Mayberry Filing No. 3
Traffic Technical Memorandum
PCD File No. SF2219
(LSC #S224210)
September 1, 2022

LSC Responses to EPC TIS Redline Comments.pdf

**PCD File No. SF2219
 Mayberry Filing No. 3
 (LSC#224210)
 Mayberry Drive & Springs Road Roundabout
 County: El Paso**

OVERALL LAYOUT OF THIS REPLAT

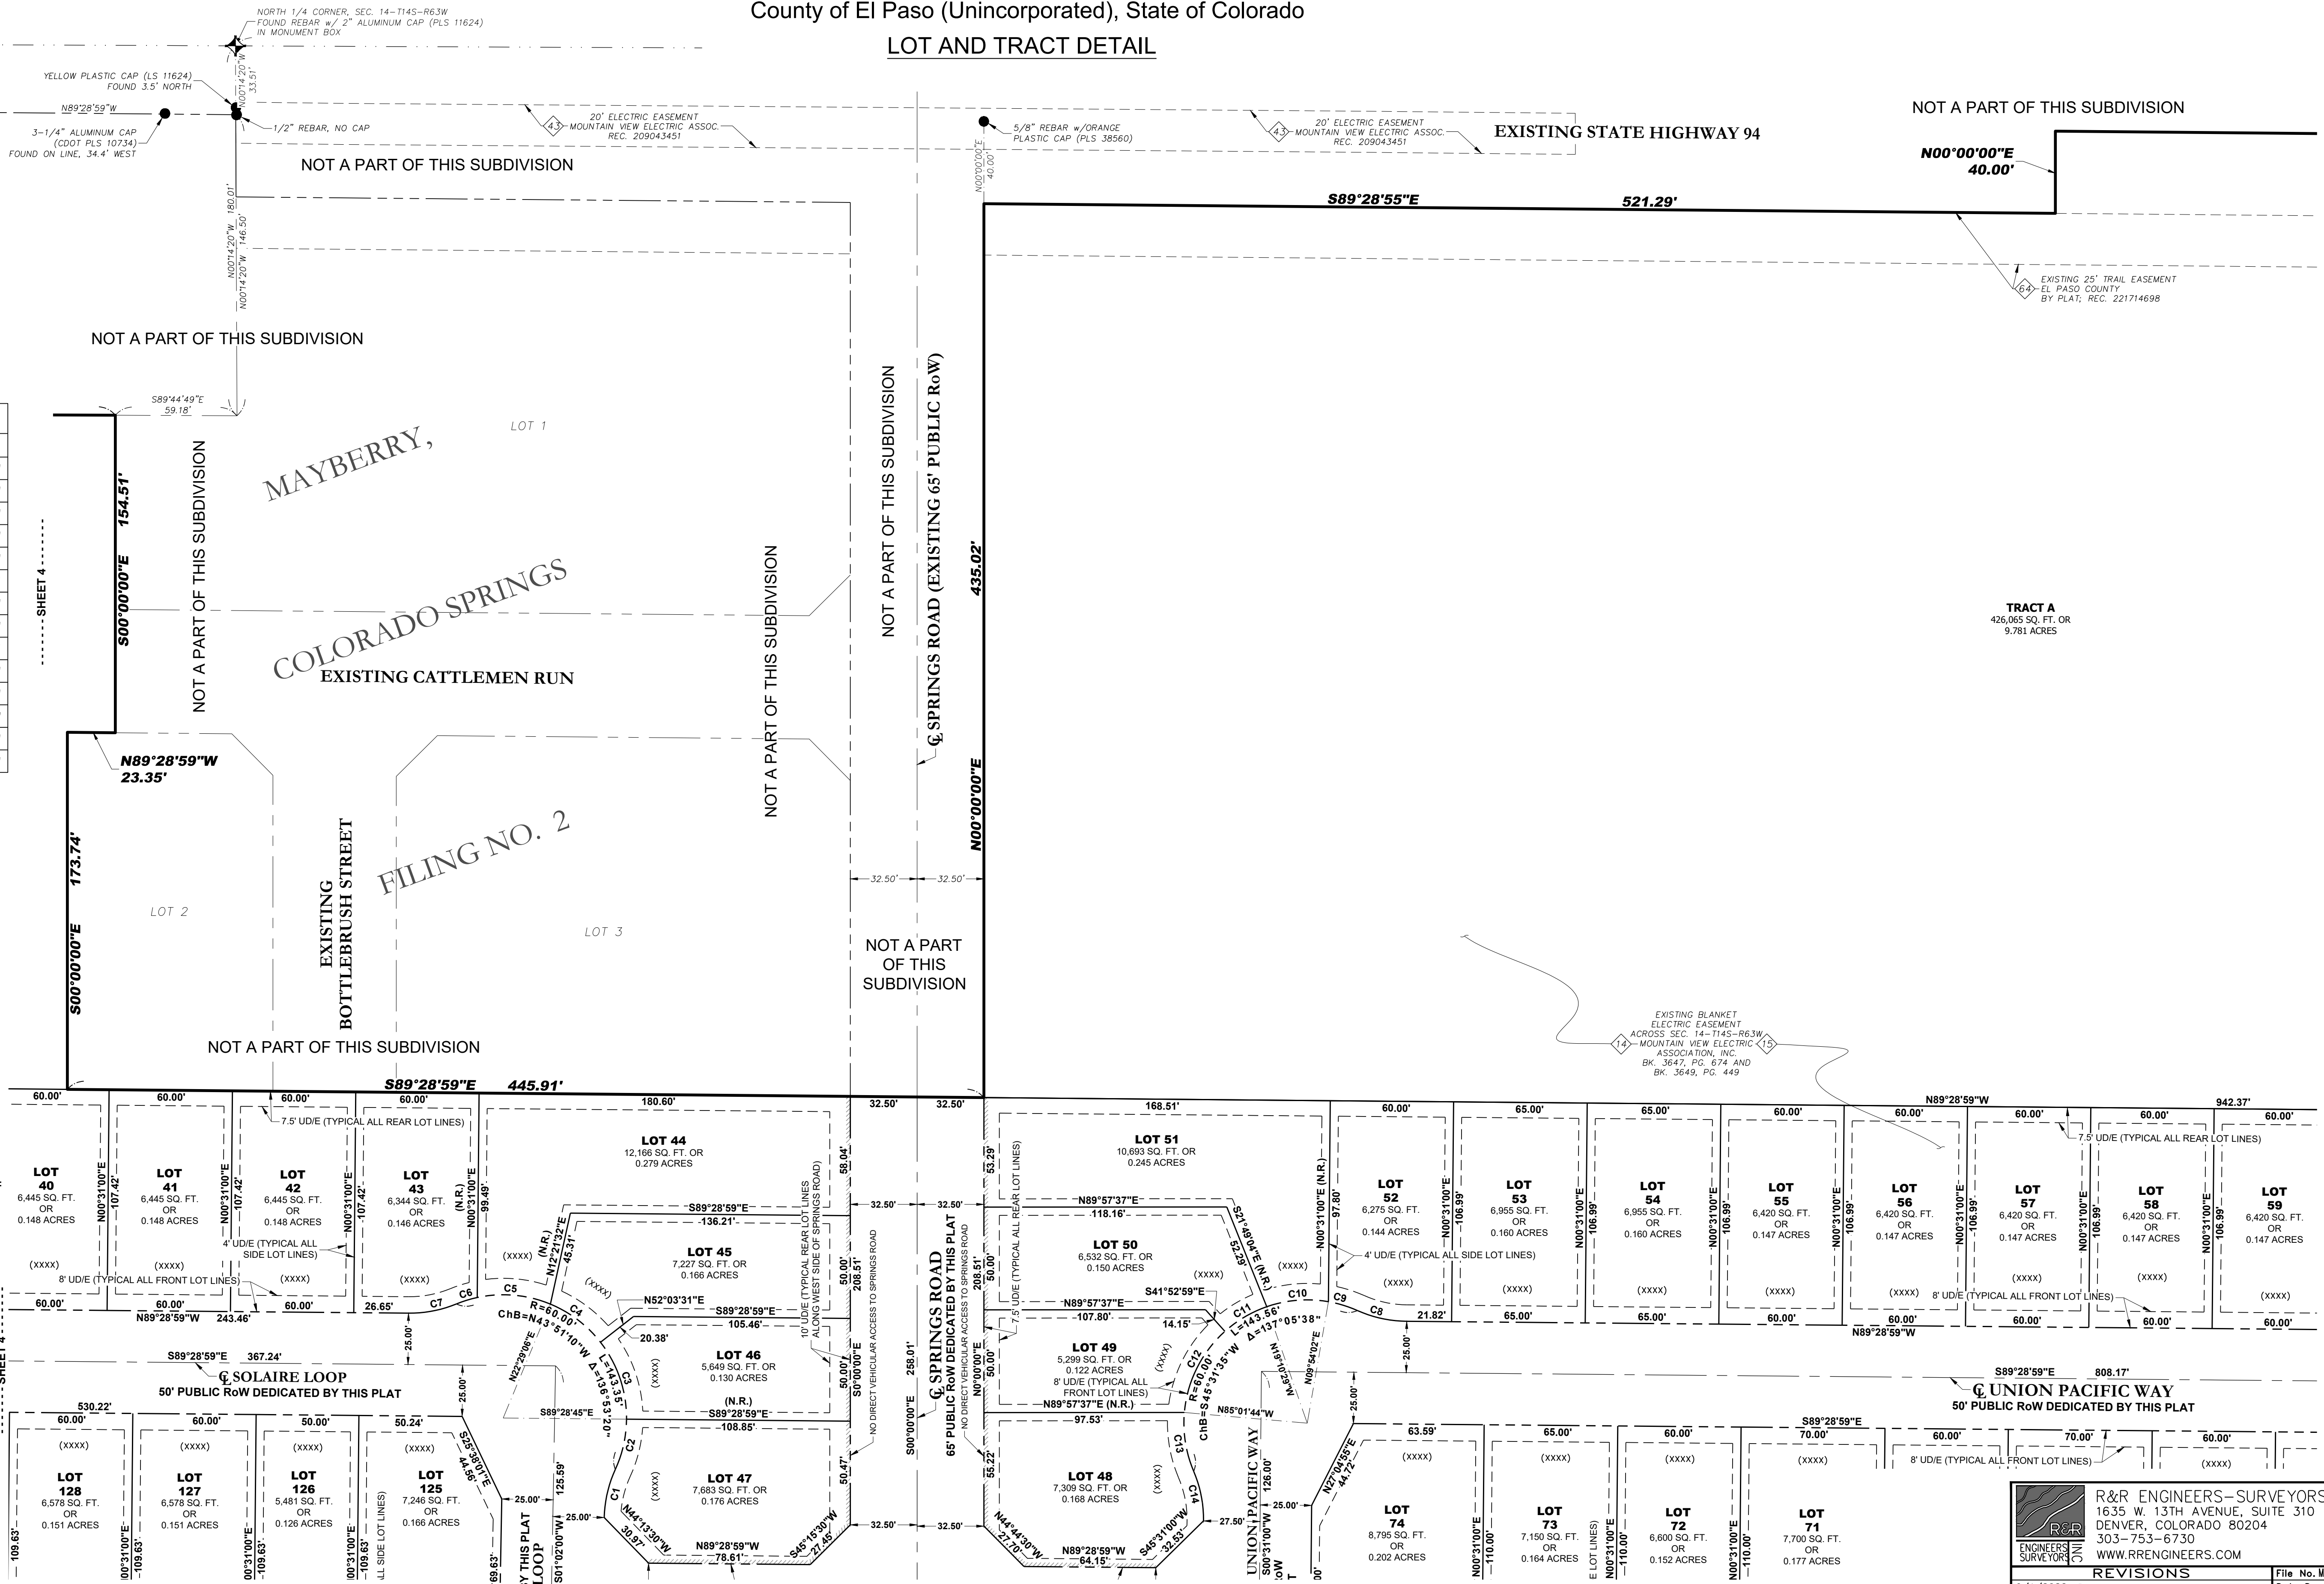
FYI: this is no longer
attached to this
document

FYI: this is no longer attached to this document

LSC Response: The plat (sheet 3) has been attached to the updated TIS report.

CONSTRUCTION DOCUMENTS	
JOB NO.	MC22110
ORG. SUBM. DATE	06/16/2022
DWN.	LAO
CHKD.	CJD
NAME	
SIGNAGE AND STRIPING - TRAFFIC CIRCLE	
NO.	C6.1

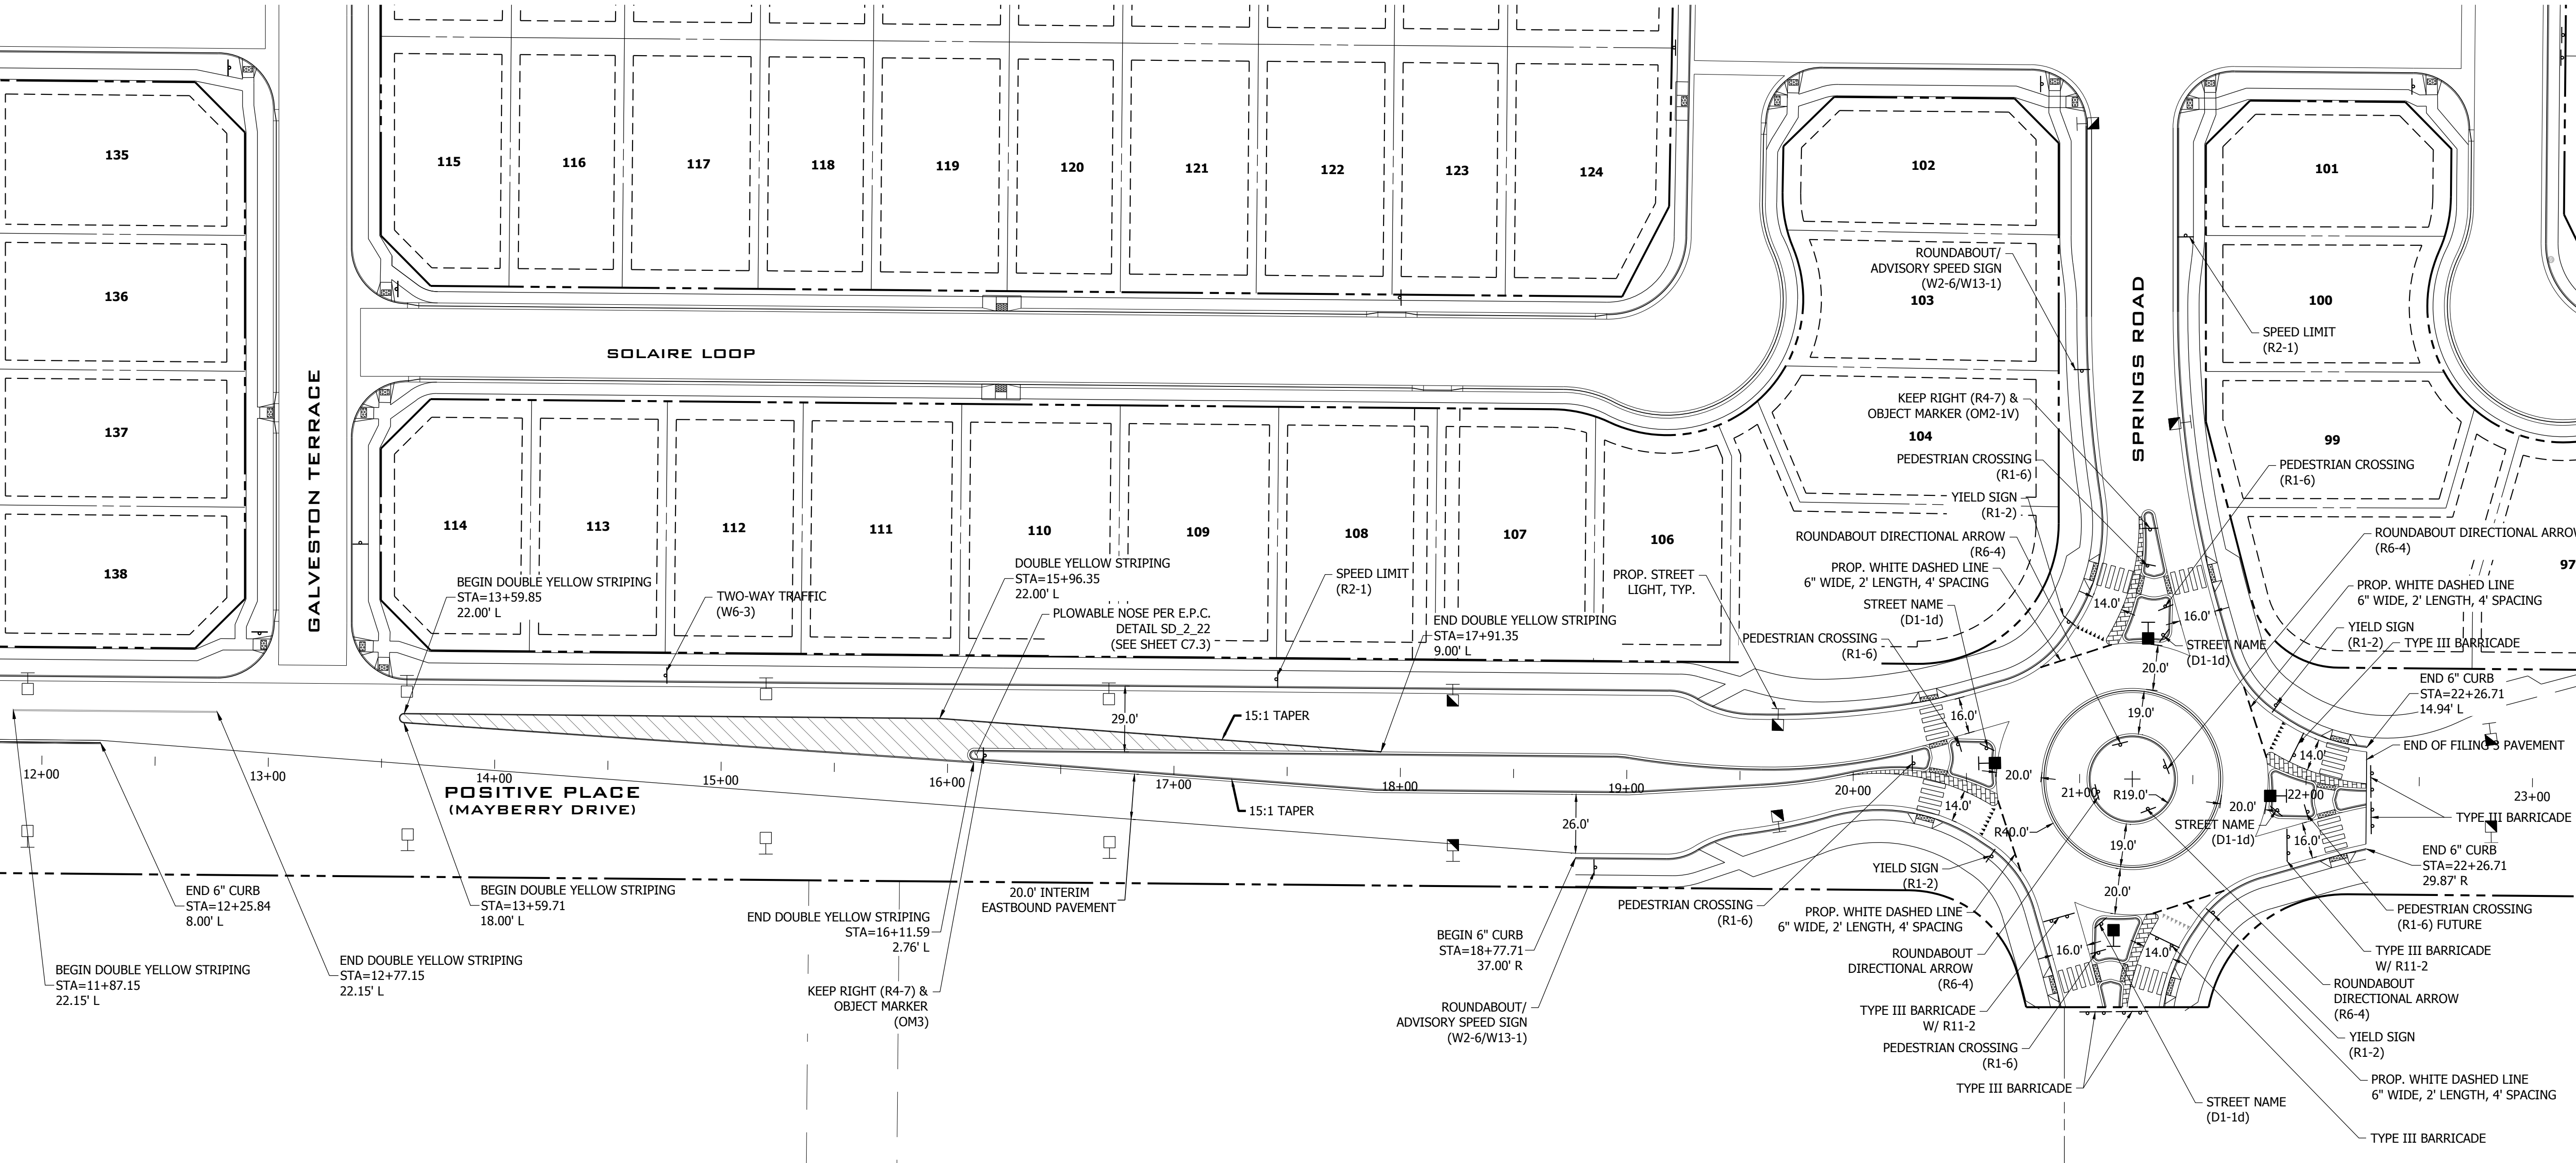
The drawing shows an entry width of 16 for each of the legs. Please clarify.

LSC Response: The 16' dimension is to the stripe only. The entry width dimension is 22.1', which is also shown.
